From: Amanda Scholes on behalf of Planning.Responses
Sent: 01 February 2018 09:22
To: Planning Scanning
Subject: FW: A/212/17/CLP

I propose that A/212/17/CLP should be considered in the same way as for A/176/17/PL (also an application for development on the area around the 9th tee of HMGC and between Ashurst and Badgers which was refused) and refused on the same points with the same recommendation.

I would further comment specifically on A/212/17/CLP that the drawing to support A/2/57 is of such poor quality that the dimensions and location of the plots in question cannot be definitely determined. The confusion is heightened by A/176/17/PL referring to three plots in the location while A/212/17/CLP only refers to two. Only one poor quality document appears to exist in the application which refers to the area of land in question.

ARUN DISTRICT COUNCIL A/21217/CLP

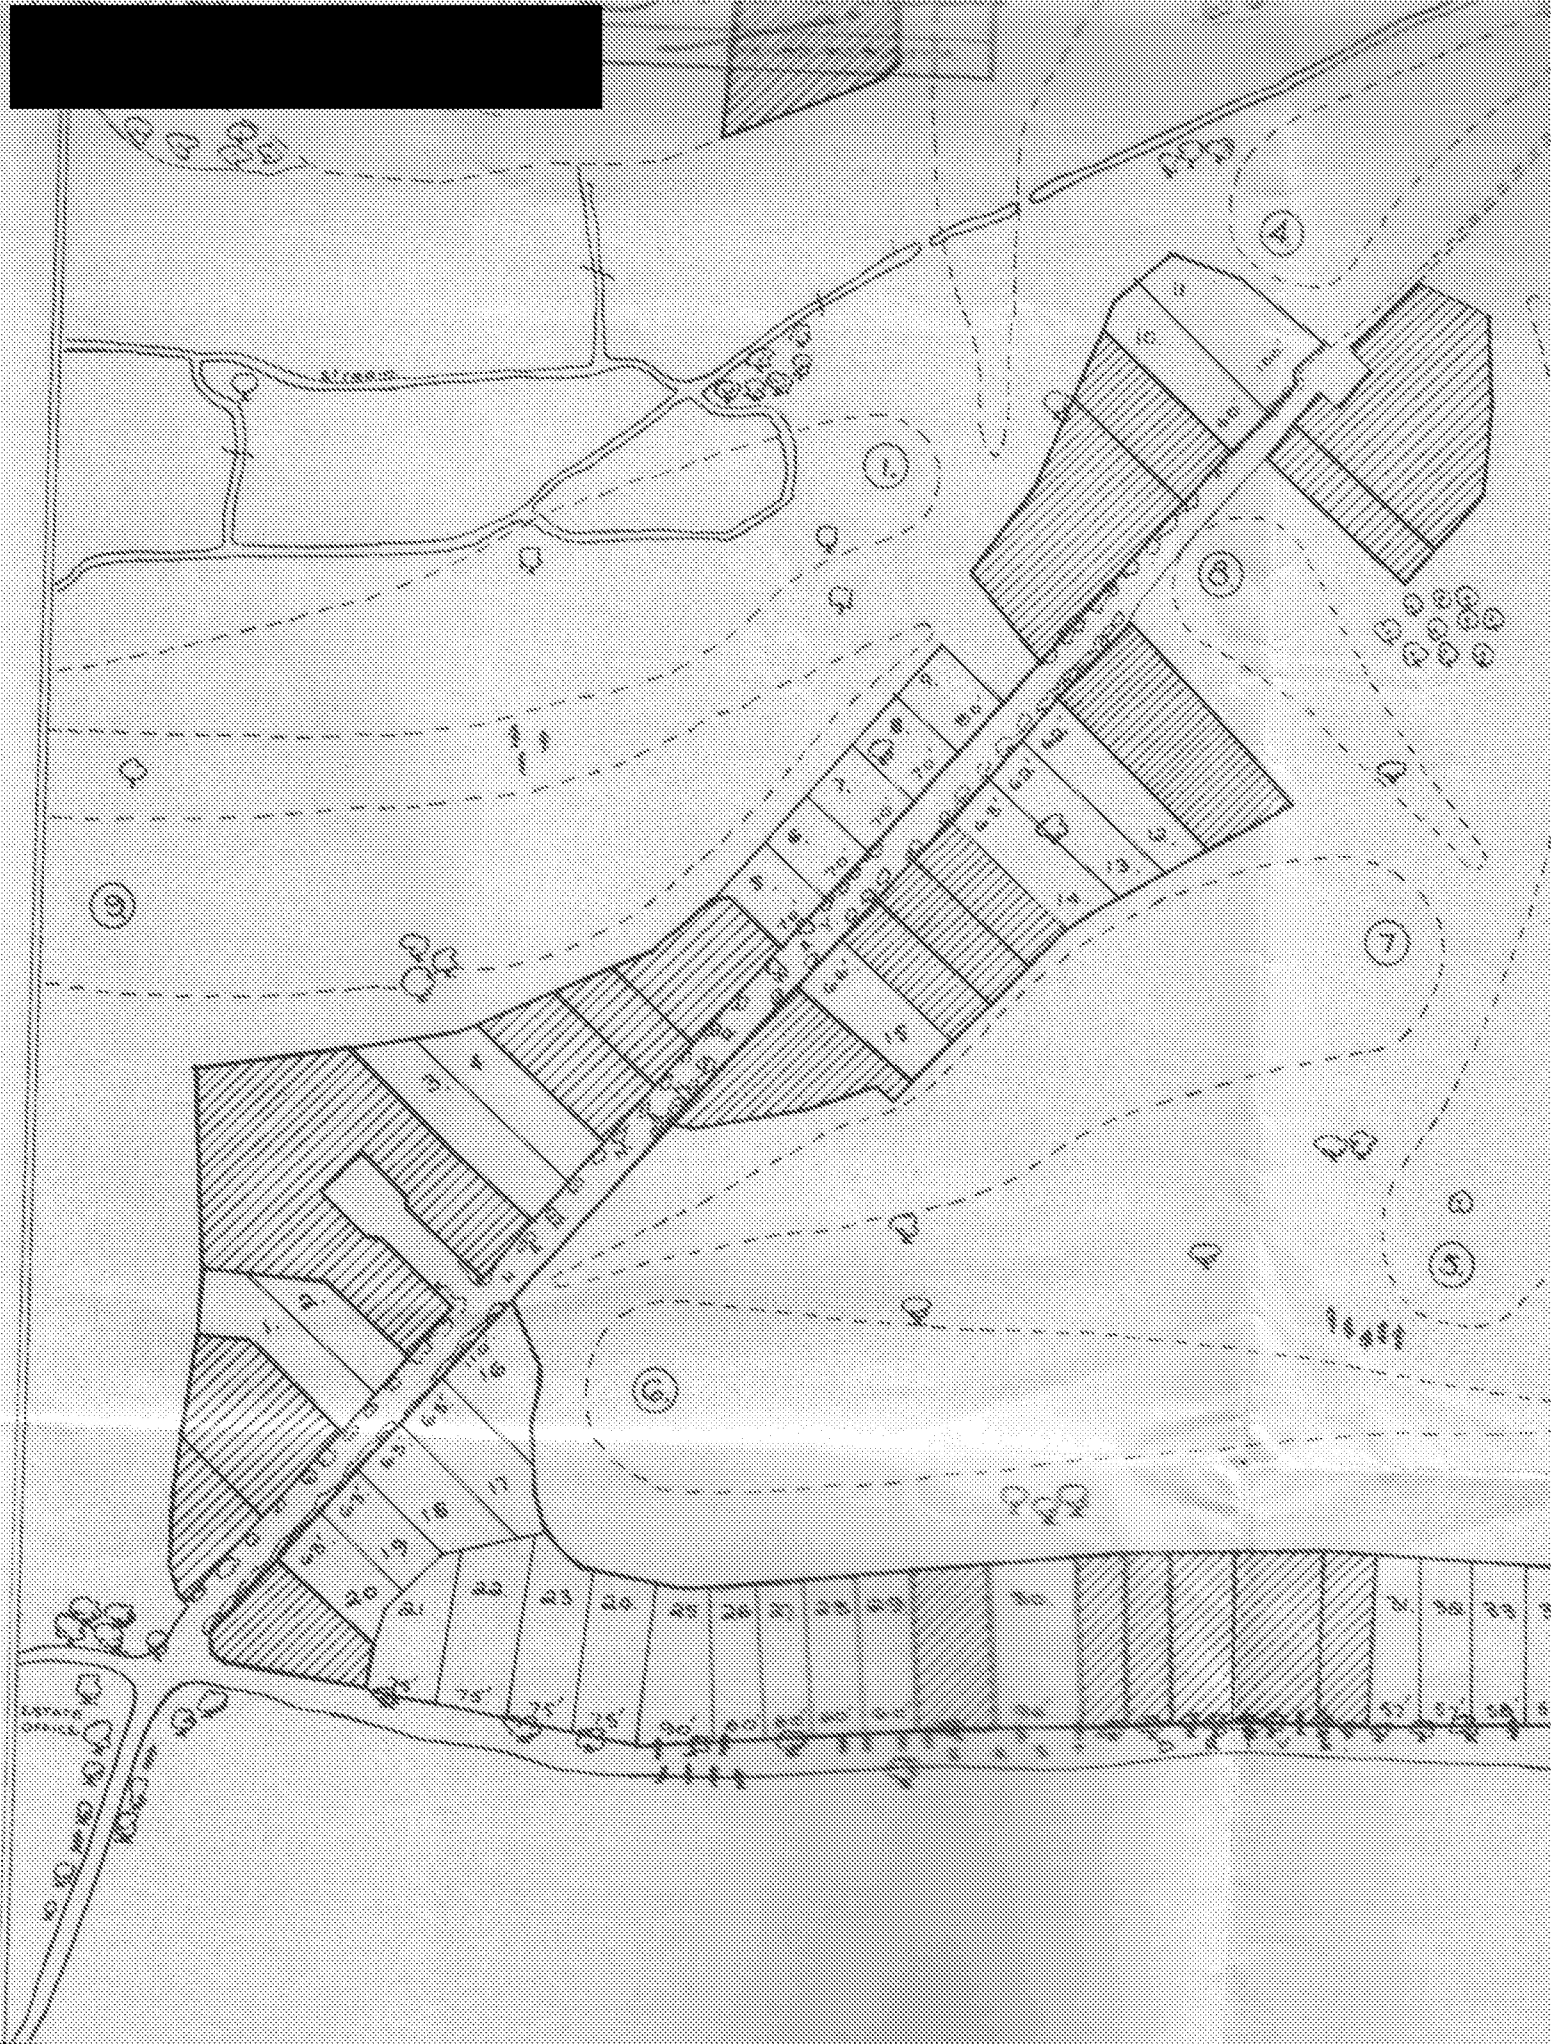
Then the plan showing the plots, should they exist, in A/212/17/CLP show the plots, outlined in red, much deeper than anything indicated by A/2/57, also that they are not parallel to Ham Manor Way as indicated by A/2/57 and appear to exist in their own island of land.
